CITY OF ALBUQUERQUE

**RE: TR A-1 Plat of TRS A-1 & A-2 Sunport Municipal Addn. (M16D024C)
2200 Sunport Blvd. SE
Grading and Drainage Plan
Engineers Stamp Date 8/26/2022**

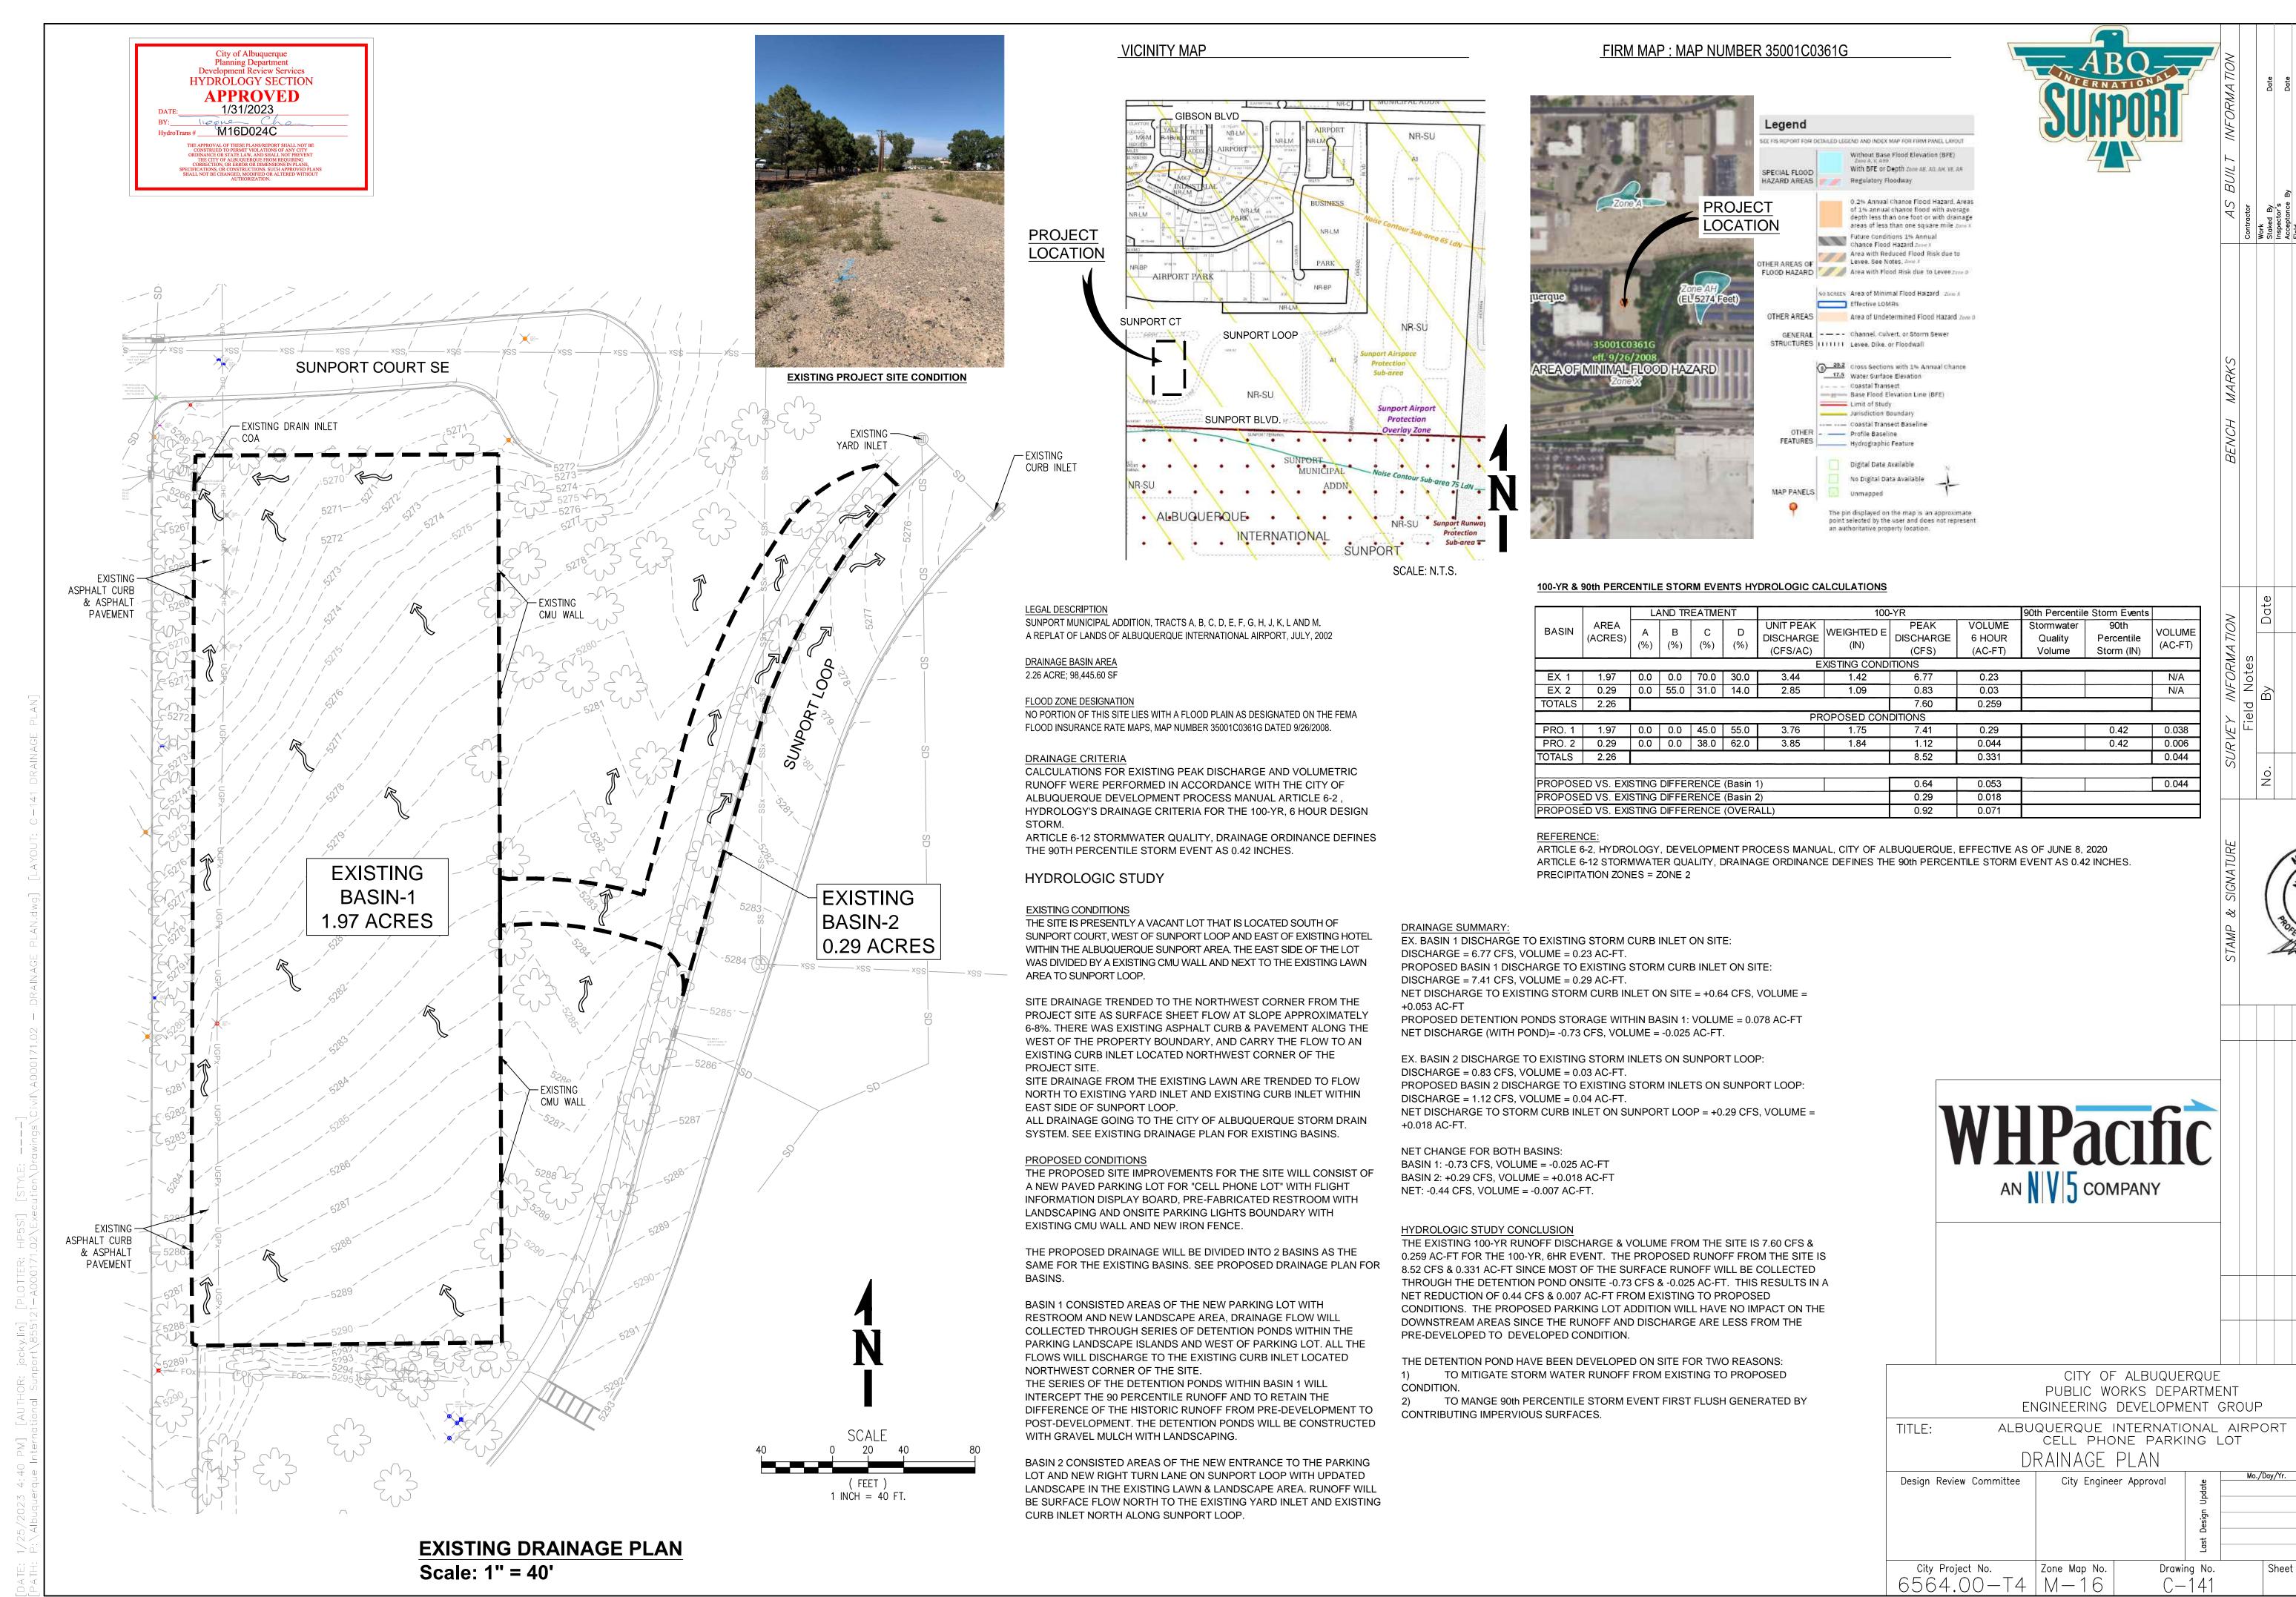
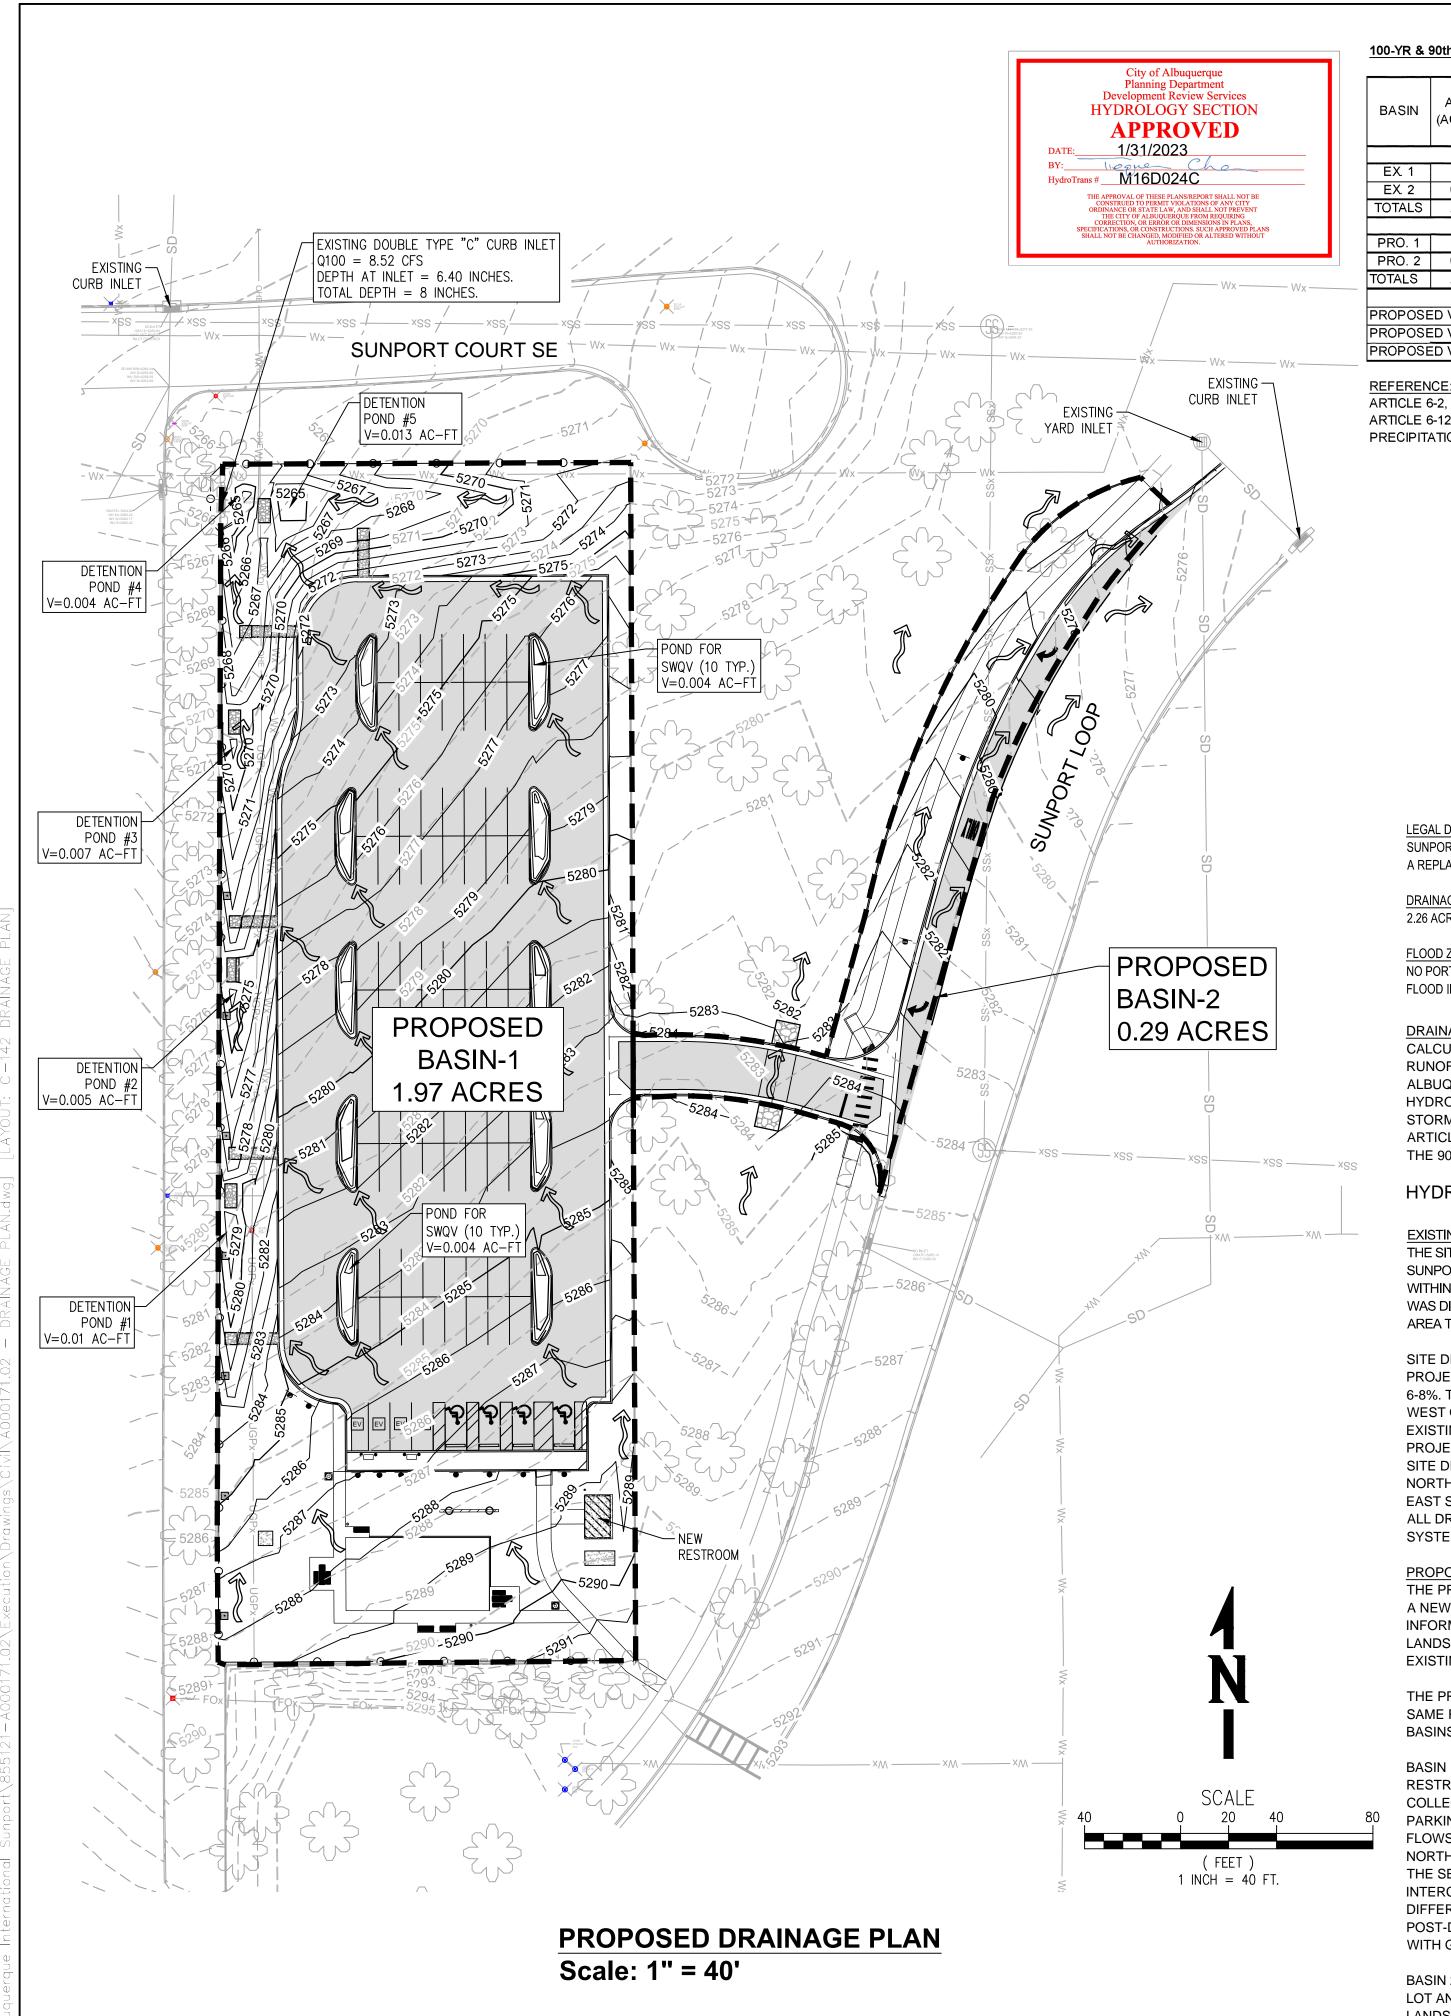
- 4) Please double check the treatment used in your runoff calculations both under the existing and proposed conditions. Under existing conditions, the treatment C is at 70%. It appears that the site is about 50% B. under the proposed conditions percentage D might be higher than show.

- 6) First Flush Volume (using storm water quality pond/retention pond) must be provided per the DPM. Detention ponds as mentioned on the plan does not address the First Flush Volume requirements.
